**KIRKLEES METROPOLITAN COUNCIL  
INVESTMENT & REGENERATION SERVICE**

**DELEGATED DECISION TO DETERMINE APPLICATIONS FOR  
NON-MATERIAL AMENDMENTS**

Reference No: **2026/NM/90407/W**

Description: Non material amendment to previous permission  
2025/92104 for erection of two storey side extension  
and extension to existing porch (within a Conservation  
Area)

Drawn No.
 101

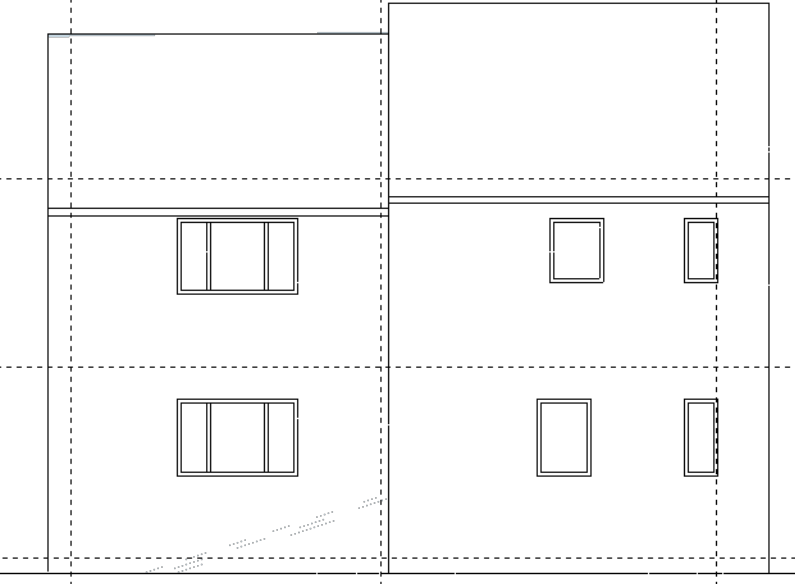
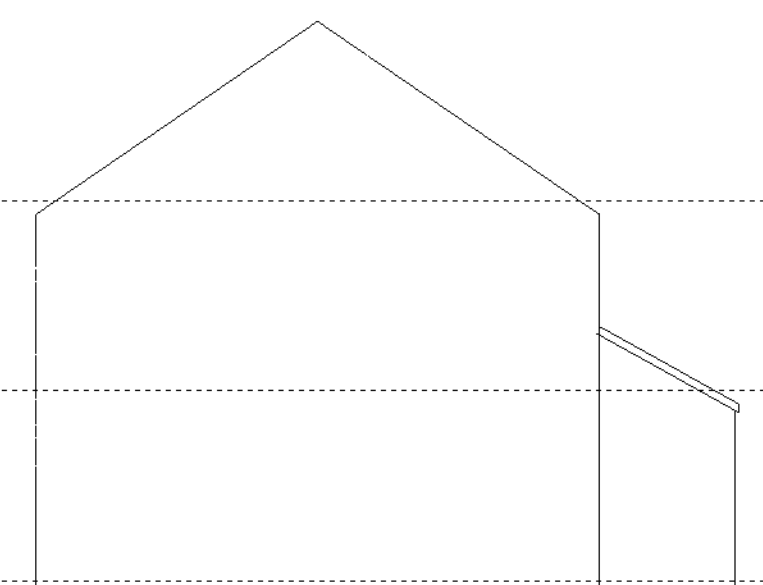
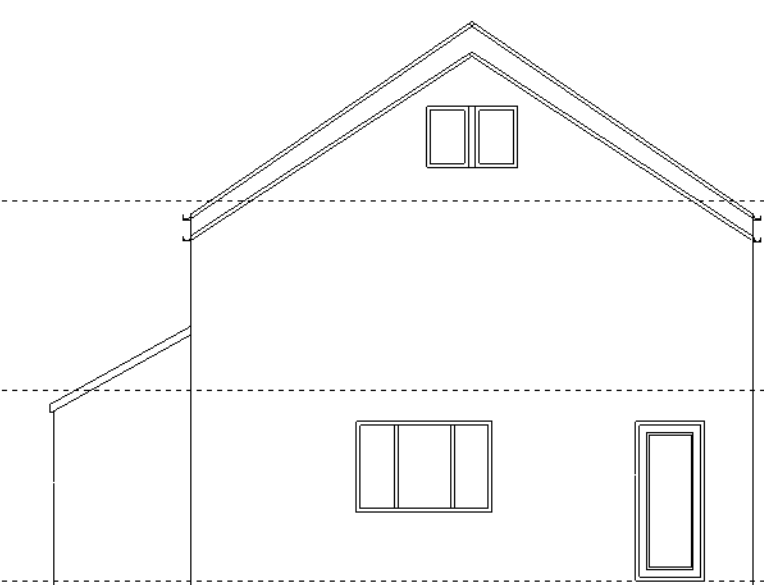
The case officer made it clear during the original application that the two-storey side extension must be reduced in overall scale, with the first floor set back to allow for a visual break and ensuring the proposal was subservient to the host property. This non-material amendment seeks to restore the originally proposed extension which was not considered to appear subservient to the host dwelling, or allow a visual break, and as such would have been refused had the original application not been amended accordingly.

It is therefore considered that the proposed change is not inconsequential in terms of magnitude and scale when compared to the original approval.

The proposed changes to the two-storey side extension would mean the first-floor element of the proposal was not set back from the ground floor, and the extension itself would not be subservient to the host property. In turn, this would detrimentally impact the property visually, allowing for no visual break between the host dwelling and extension, as well as allowing a side extension

which is not subservient to the host property and therefore does not comply with the Councils House Extensions and Alterations SPD.

The proposed amendment to 50 Birkby Lodge Road would cause the development to no longer comply with Policies LP1, LP2, and LP24 of the Kirklees Local Plan, Chapters 2 and 12 of the National Planning Policy Framework, and policies within the Councils House Extensions and Alterations SPD.

The amendments shown on drawing No's. 100 and 101 are not considered appropriate to be regarded as a non-material amendment to the previous planning approval 2026/90407 and refusal is recommended.
